Your Ref: OWPC18549
Our Ref: WA/26/18/OUT 22-03-2018
Please ask for:
Mr J Baeza

Outline application with all matters reserved for 6 No detached houses with detached garages. This application is a Departure from the Development Plan.

Former Lanes End House Adjacent to West Walberton Lane & Arundel Lane Walberton

Former Lanes End - Six Six bedroom detached Houses with Garages Proposed Layout Scale 1:100 @ A3 (c) PJ Developments LTD 2018		REVISIONS		01
		MM/DD/YY	REMARKS	
	1	--/--/--	...	A
	2	--/--/--	...	
	3	--/--/--	...	
	4	--/--/--	...	
	5	--/--/--	...	
West Walberton Lane Proposal

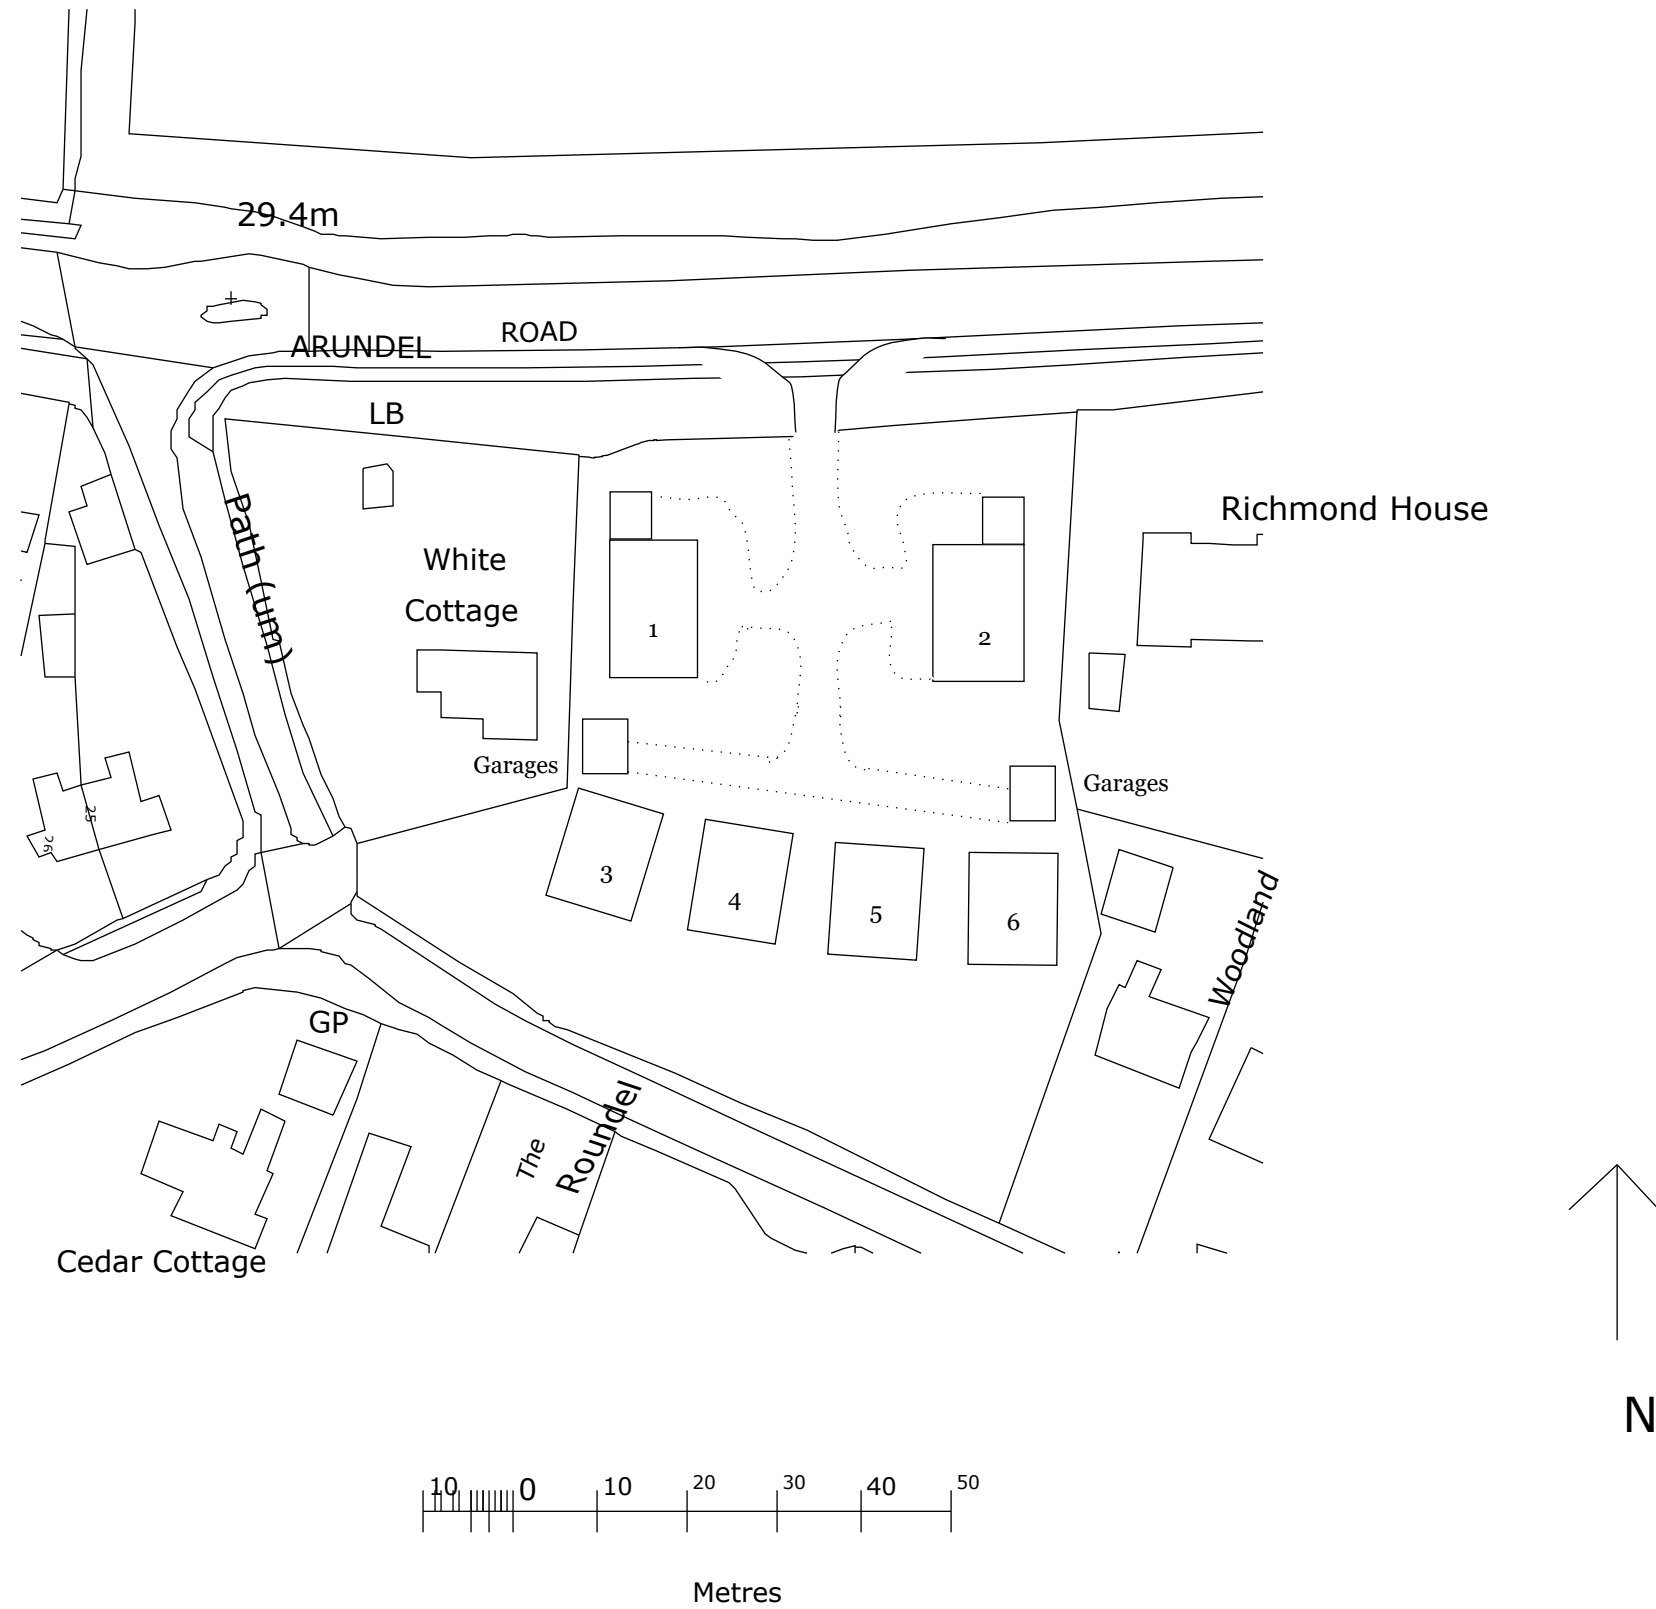
The three storey homes with 6 bedrooms are not in keeping with the surrounding properties which are bungalows and two story houses. They might well be of interest to potential buyers as flats.

Car parking is shown as 26 spaces, 8 of which are in garages. This is a location not served well with supermarkets, schools, surgeries, banks, churches etc so car use will certainly be very much required. Bicycle storage spaces will be needed to support sustainable transport ideals. The site is very much rural in character and the removal of well established bushes and trees will affect the wildlife in the area. Although the site entrance is on Arundel Road traffic travelling to Walberton, Barnham, Bognor Regis, Yapton and Littlehampton would tend to use either Wandleys Lane or West Walberton Lane which are very much unsuited to having even more additional journeys placed upon them.
